## DEPARTMENT OF PARKS AND COMMUNITY SERVICES

September 1, 2023

**Subject: Davis Ranch Sketch Plan, Preliminary Comments (SKP-23-002)**

PLAN SCALE: 1" = 300' OR AS NOTED ON PLAN
 SHEET TITLE: SKETCH PLAN
 SHEET NO. SKP1.1
 1 OF 3 SHEETS
 FILE NO. FILE#

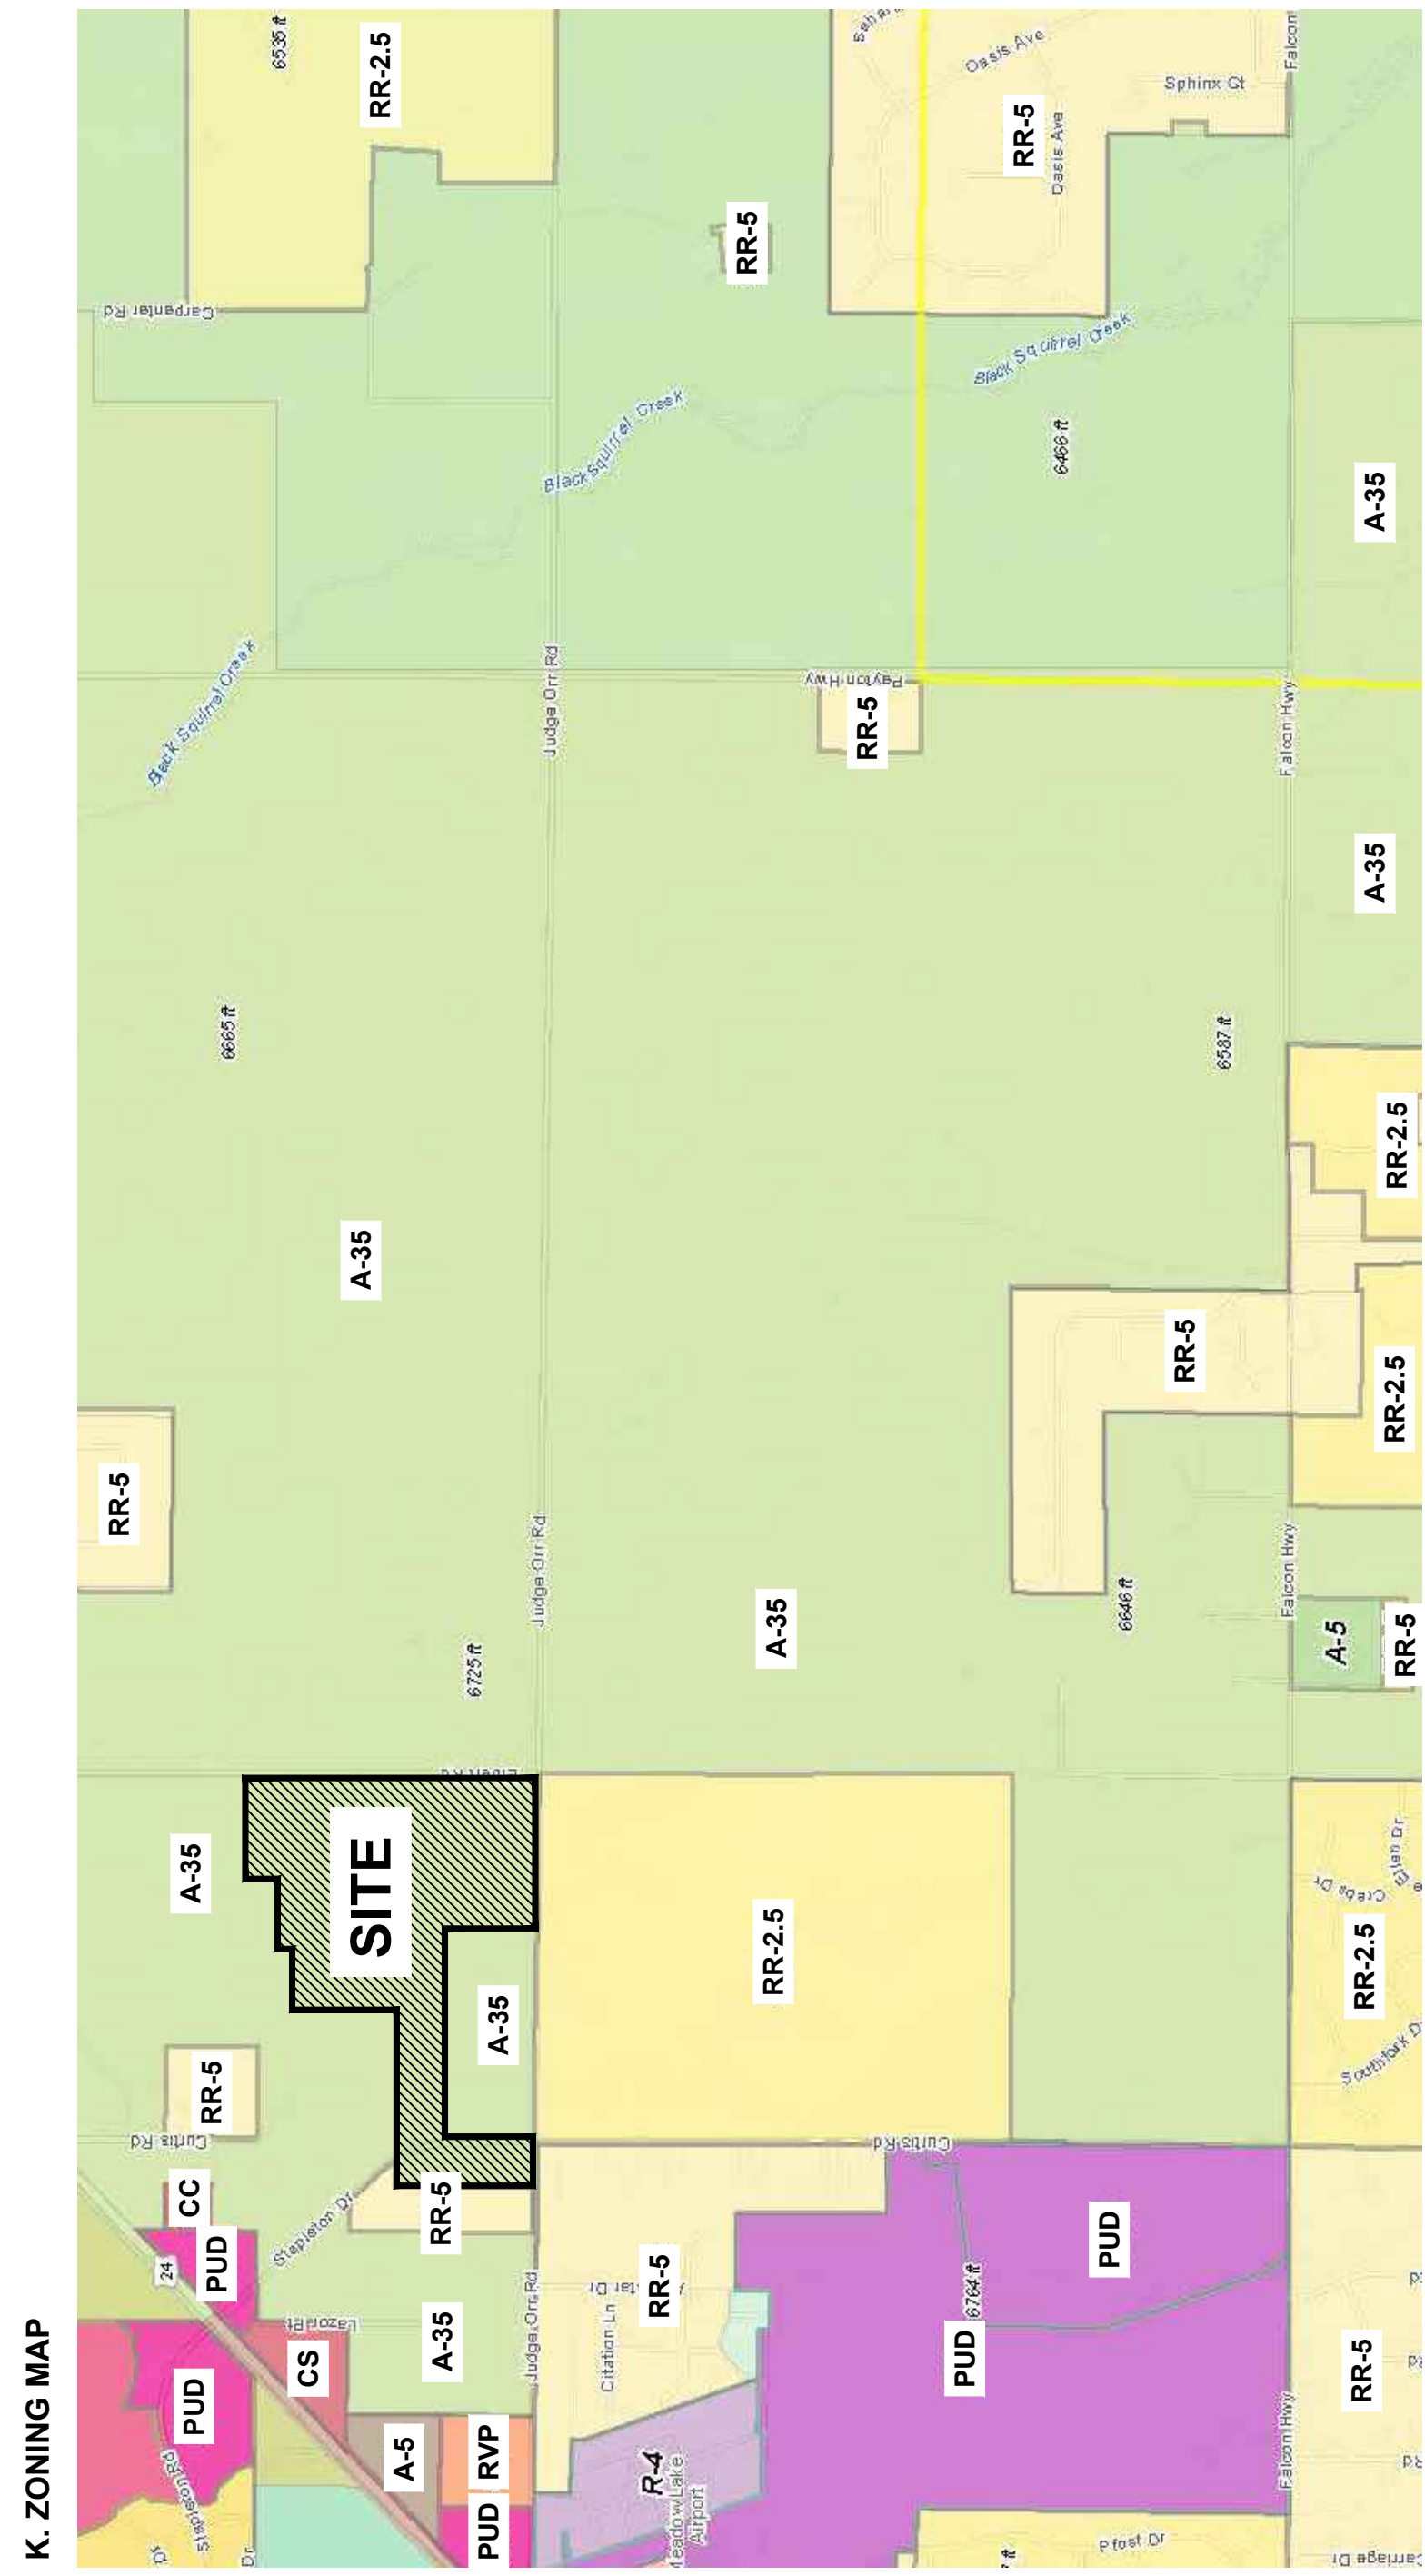
In addition to the assessment of regional park fees, El Paso County Parks recommends that the applicant designate and provide to El Paso County a 25-foot trail easement along the north side of Judge Orr Road from the project's western boundary to the intersection of Judge Orr Road and Stapleton Drive/Curtis Road, in Parcel A, that allows for public access, as well as construction and maintenance by El Paso County of the Judge Orr Road Secondary Regional Trail, and show the easement on the forthcoming Preliminary Plan and Final Plat(s), and dedicate the aforementioned easement to El Paso County prior to the recording of the Final Plat(s).

*The Park Advisory Board recommends that the Planning Commission and the Board of County Commissioners include the following condition when considering and/or approving the Davis Ranch Sketch Plan: (1) designate and provide to El Paso County a 25-foot regional trail easement along the north side of Judge Orr Road from the project's western boundary to the intersection of Judge Orr Road and Stapleton Drive/Curtis Road, in Parcel A, that allows for public access, as well as construction and maintenance by El Paso County of the Judge Orr Road Secondary Regional Trail; (2) show the regional trail easement on the forthcoming Preliminary Plan and Final Plat(s); (3) dedicate the regional trail easement to El Paso County prior to the recording of the Final Plat(s); (4) fees in lieu of land dedication for regional park purposes in the amount of \$46,460 will be required at time of the recording of the forthcoming Final Plat(s).*
